From: Mark Batchelor [mailto: [REDACTED]]
Sent: 31 March 2015 09:57
To: Simon Davis
Cc: David Bevan; 'Laura Murphy'; Dave Webb; Kris Robertson
Subject: Ship Inn, Bognor - Signage Application - YOUR REF: AW/25/15/A
Importance: High

FRONT ELEVATION

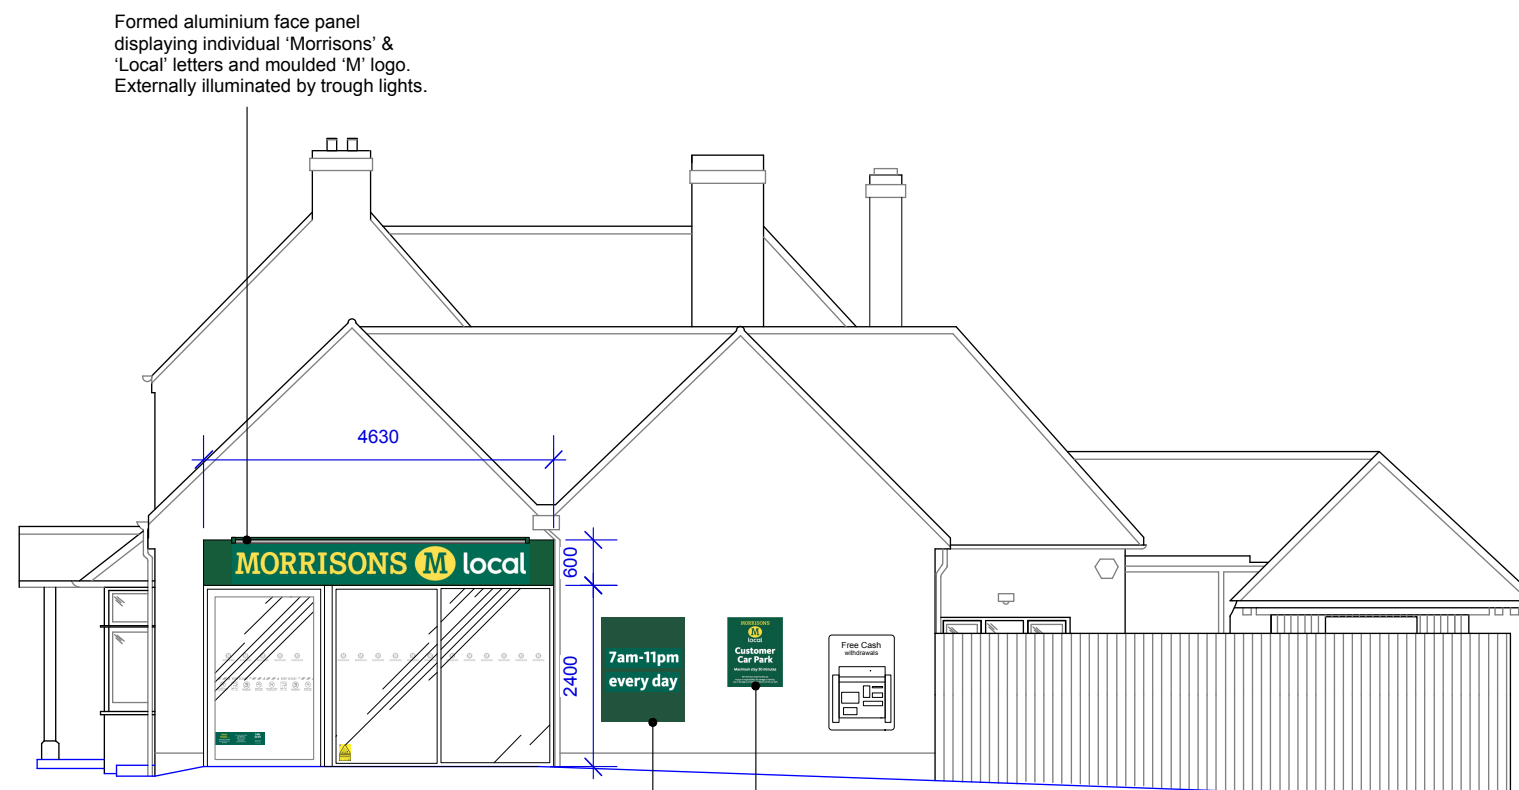
- Front elevation sign: The company's brand name is "Morrisons M Local" and as such, no change can be made to the wording of the sign. I would further point out that the suggested amended wording: "M Local at The Old Ship" would inevitably be larger than the sign proposed in this application. I have reviewed the conservation officer's comments connected with the original signage application and they do not appear to have raised any objection to the internally illuminated sign which was proposed on the front elevation. The sign now proposed addresses the committee members' concerns regarding design and method of illumination and to my mind it would not cause harm to public amenity in the ASC. I further consider it to be in keeping with the building's character and the character of the surrounding area.

SIDE ELEVATION

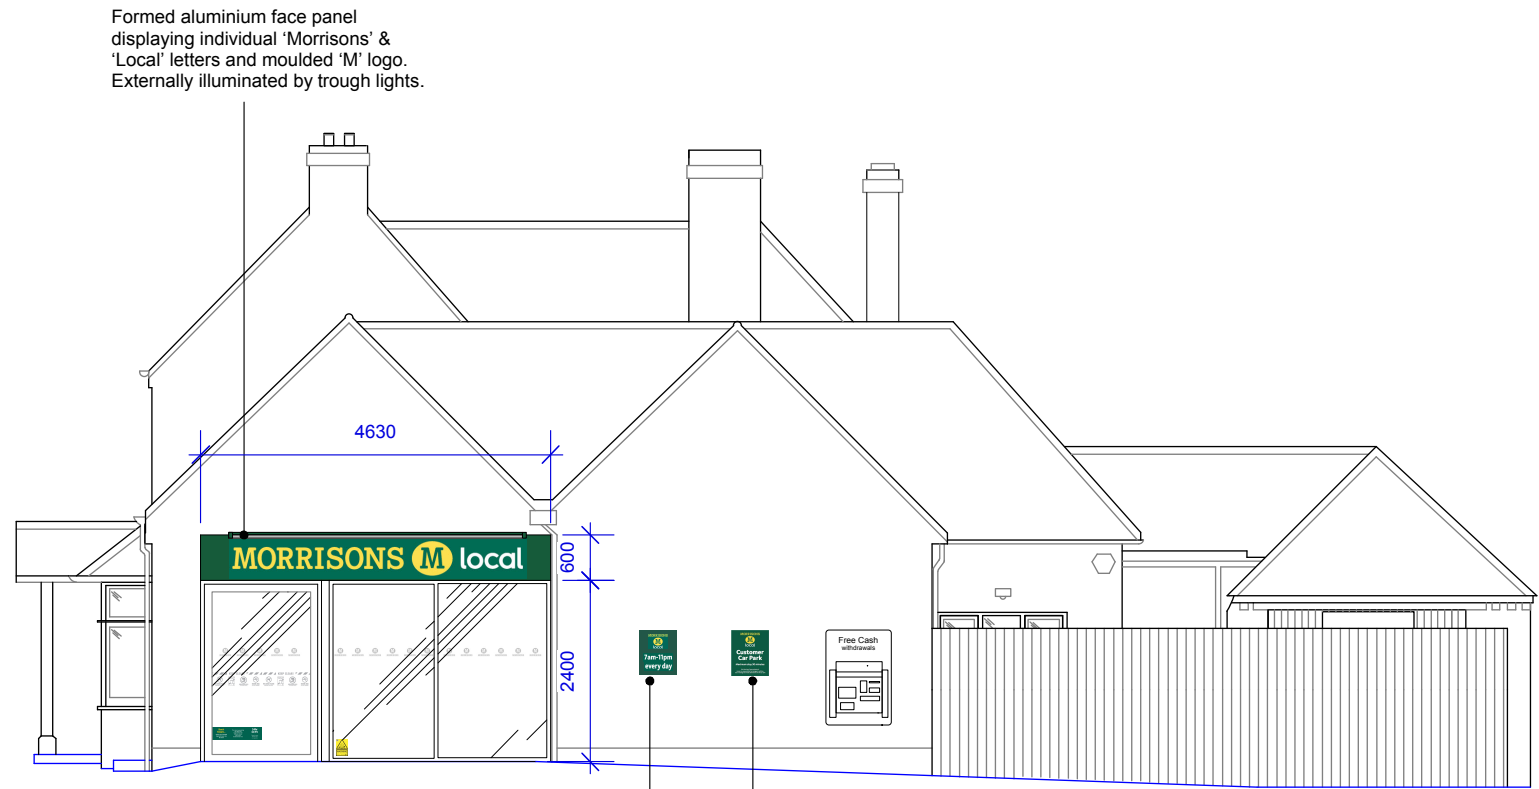
- Side elevation (main entrance): Here we have amended the originally submitted drawing, reducing the size of the car park and opening hours signs and repositioning them so as to align with the top of the approved ATM. The signs are now 0.3sqm in area and as such benefit from Deemed Consent under Schedule 3, Part 1,

Class 2 of the Control of Advertisement Regulations (2007). I attach an amended drawing (no: D225E (to replace D225C)) showing the proposed signs.
